Preliminary Acceptance Punchlist
El Paso County – Department of Public Works - Stormwater Section

Project Name:	Solace of Colorado Springs Channel Improvement
EDARP Filing Number(s):	CON2165, SF2032
ESQCP Number:	ESQ2142
Attendees:	DPW Stormwater: Natasha Grimaldo DPW Development Services: Brad Walters and David Parkerson Developer: Kelsey York and Manmit Jadav
Date of Walk-Thru:	01/31/2024
Walk-Thru Number:	1 st

SAND CREEK-CENTER TRIBUTARY CHANNEL PROFILE (4)
STA 11+00.00 TO 16+50.00

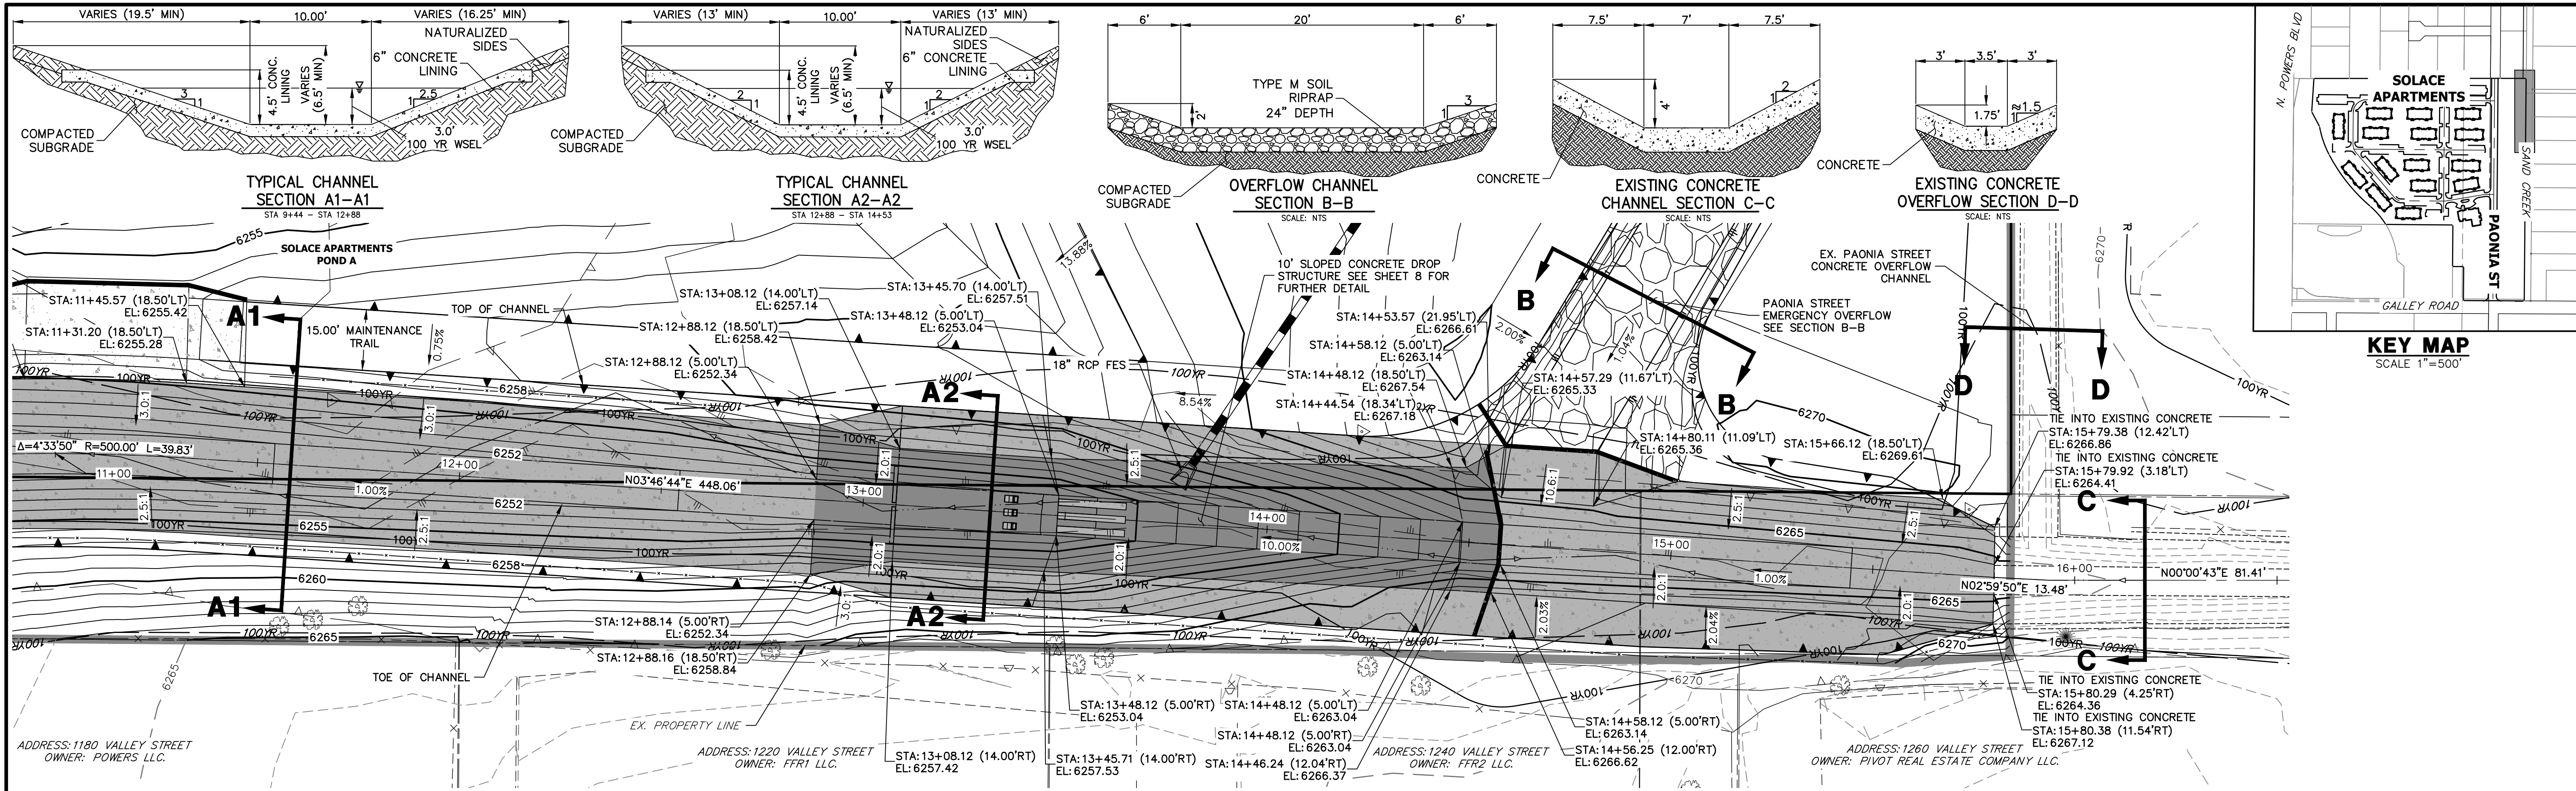
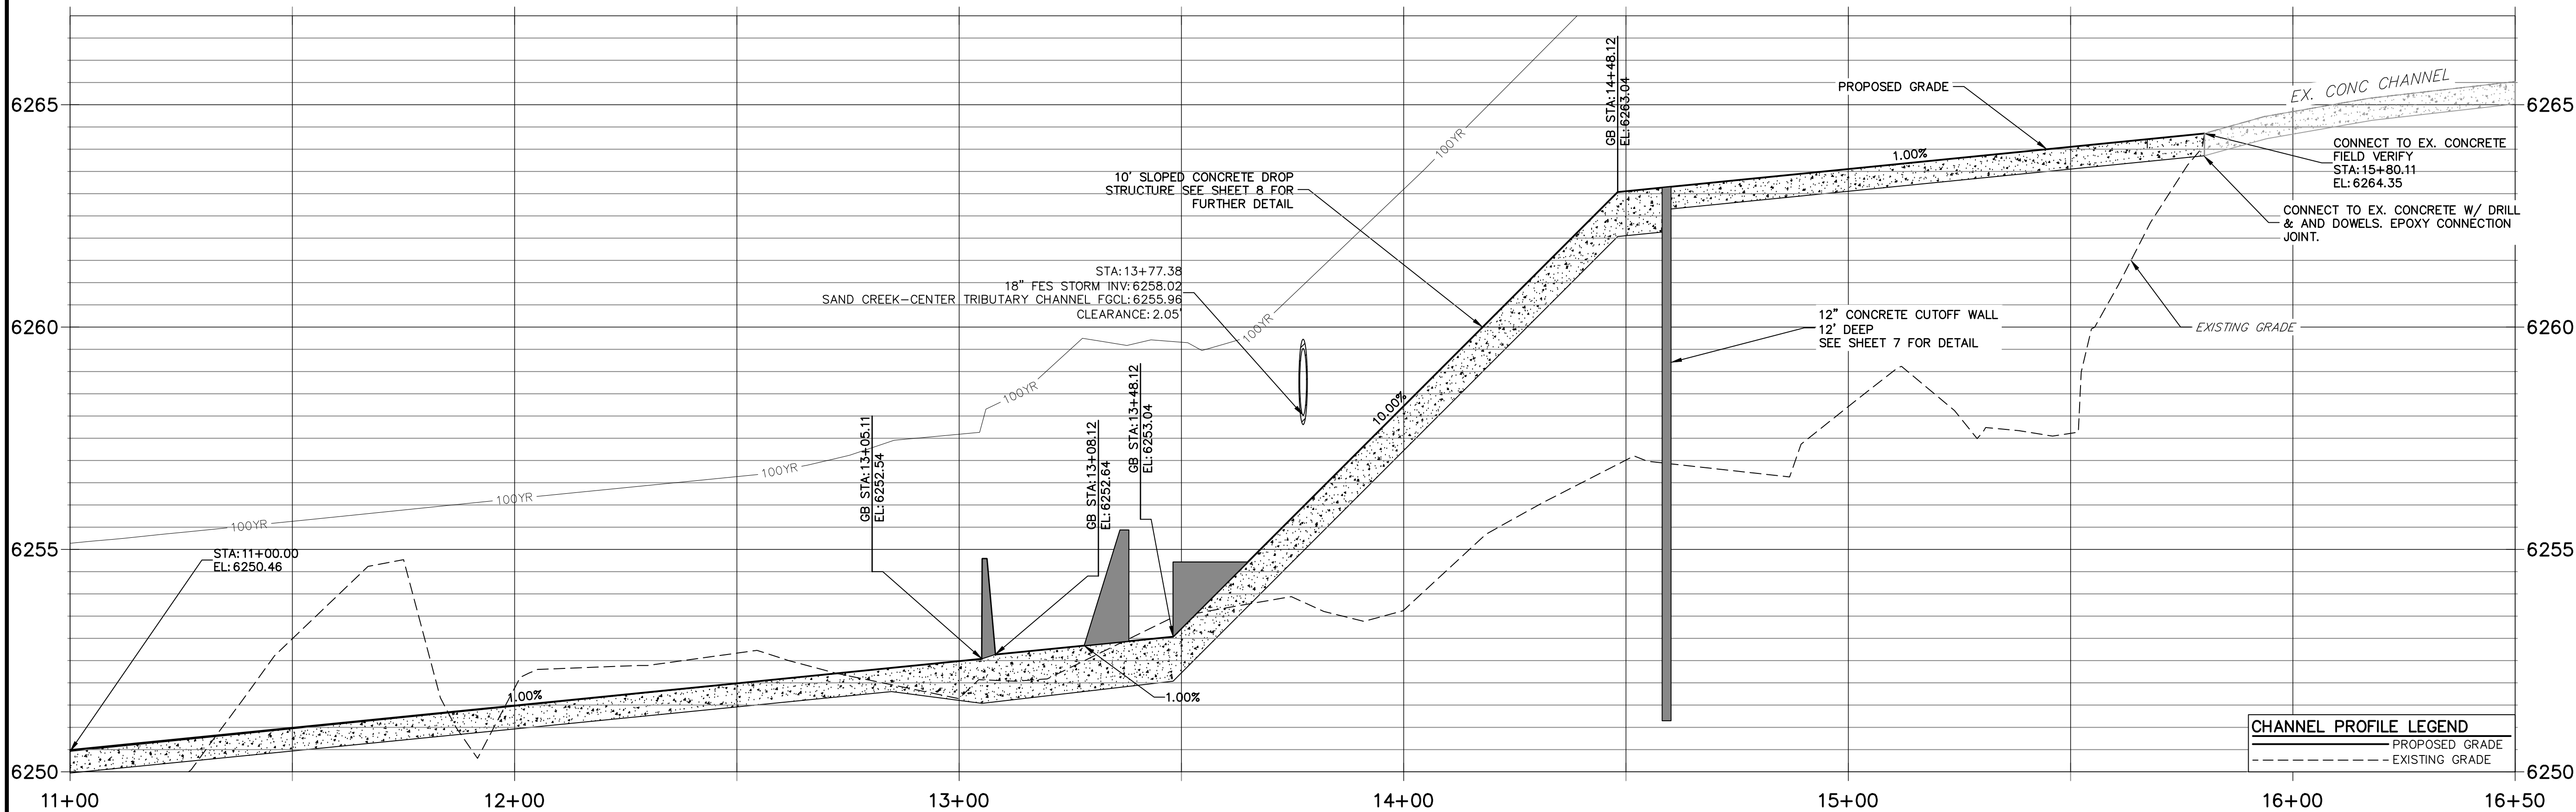
- Approximately STA 14+05: Repair chipped concrete. Reference Photo 2.
- Approximately STA 13+00: Low spot is causing water accumulation. Adjust grade to match the approved 1% slope to promote positive drainage. Reference Photo 5.
- Approximately STA 11+00: Fine grade rill erosion along slope and stabilize. Reference Photo 6.

**DROP 1 PROFILE
STA 13+00.00 TO 14+65.00**

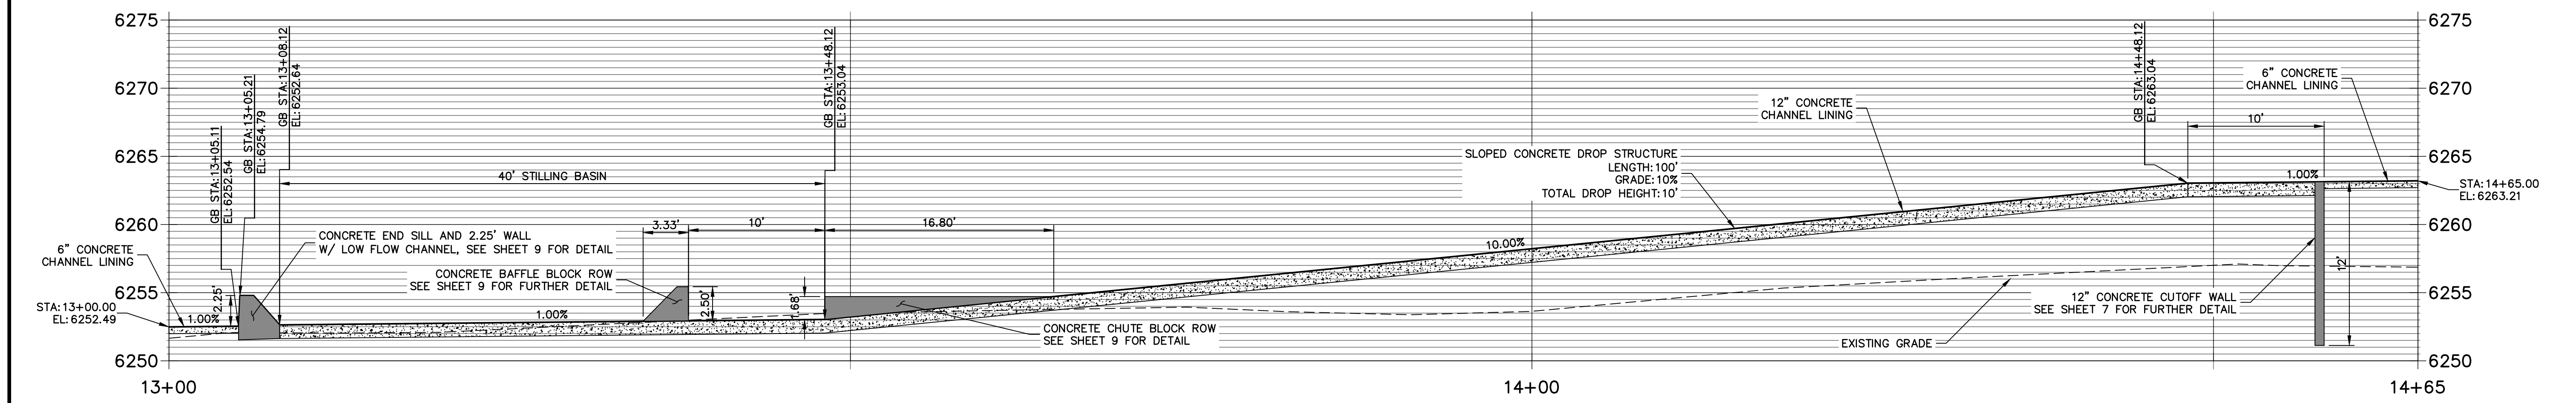
Photo 4: Concrete Sill Wall at STA 13+05 deviates from approved design. Plans call for a height of 2.25'. Reference deviation on the As-builts.
